Comment for planning application 21/01437/F

| Location | New Rectory Acre Ditch Sibford Gower OX15 5RW |
| Proposal | Two storey detached replacement dwelling with semi basement |

drwg no 253\_04\_301 rev P4  
title Proposed Elevations II  
scale 1:100 @ A3

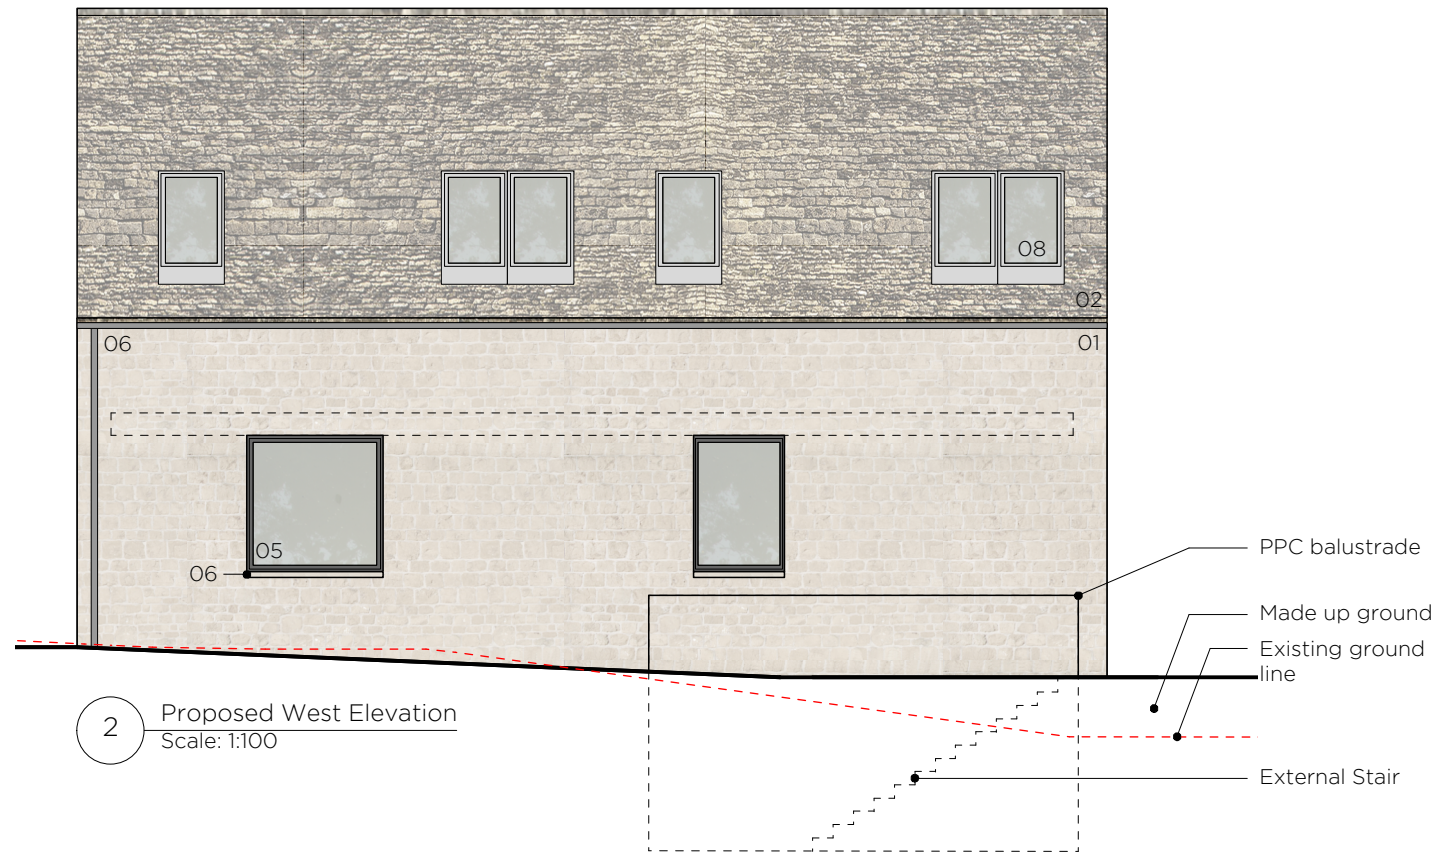
| Comments | <p>Application No: 21/01437/F Location: New Rectory - Two story detached replacement dwelling with semi basement. We are the immediate neighbours to the East of the New Rectory and would like to make the following comments on this planning application, No: 21/01437/F, as we feel unable to fully support the application as submitted. Firstly, we are very pleased that a young family have chosen to make their long term home in the village, and we do support the following aspects of this application: The proposal for a single "two story detached replacement dwelling with semi basement" , which appears to comply with the restrictive covenant included in the applicant's purchase of the property/ plot. The positioning, footprint and scale of the proposed replacement dwelling - though a larger dwelling, appears to be reasonable, provided there is no significant extension, or addition of outbuildings at a later date. The proposal for only small secondary windows on the Eastern elevation with the offer of obscure glass is welcomed. However, there are some aspects of the application that we have concerns about and would request these are covered by suitable planning conditions if this application were to be approved: Future applications for a garage, additional accommodation or significant outbuildings. We have strong concerns regarding any future provision of a garage or outbuildings, with or without additional accommodation. We would object to any significant expansion of scale between the proposed dwelling and anywhere along the Eastern boundary with our own property (Oaklands). We would request that these issues are covered by a suitable conditions. Sustainable energy systems. Whilst we support in principle the use of sustainable energy systems for the proposed dwelling, we are concerned at the lack of detail offered at this stage. We are encouraged by the applicant's promise of sound insulation of the semi-basement plant room, but are concerned about the visual impact, and in particularly any likely noise nuisance from external heat exchangers, or other plant that we believe may be unavoidable. We would request a clear condition limiting external noise is included in any approval. External finish. The proposed external finish of the new dwelling following pre-application guidance is a cause for concern given the differing interpretations offered by the applicant and the applicant's architect. We have no objection to a stone or rubble stone finish that is lighter than the ironstone typical in the Sibfords, and as described by the applicant - provided that it is not of the yellow colour more typical in Chipping Norton. We would not like to see a "semi-translucent lime wash finish" favoured by the applicant's architect, as the example of such a "semi-translucent lime wash finish" offered by the applicant's architect - of their own offices in Hook Norton appears to be solid matt white with no discernible translucency. Construction nuisance: The proposed application for the replacement dwelling will involve major construction activity - including complete demolition of the existing structure, excavation of the semi-basement, Extensive ground works and levelling, along with major construction activity for the replacement domestic dwelling. We would request that clear enforceable conditions are attached to any approval, to minimise nuisance to neighbours, including restrictions and guarantees on: period of construction, working hours; vehicle access and parking; dust and air pollution; noise and light pollution, groundwater pollution and flood risk; and health and safety both on and off site. We hope that you are able to fully address our concerns by suitable conditions if this application were to be approved. David & Marianne Allen Oaklands, Sibford Gower OX15 5RW</p> |
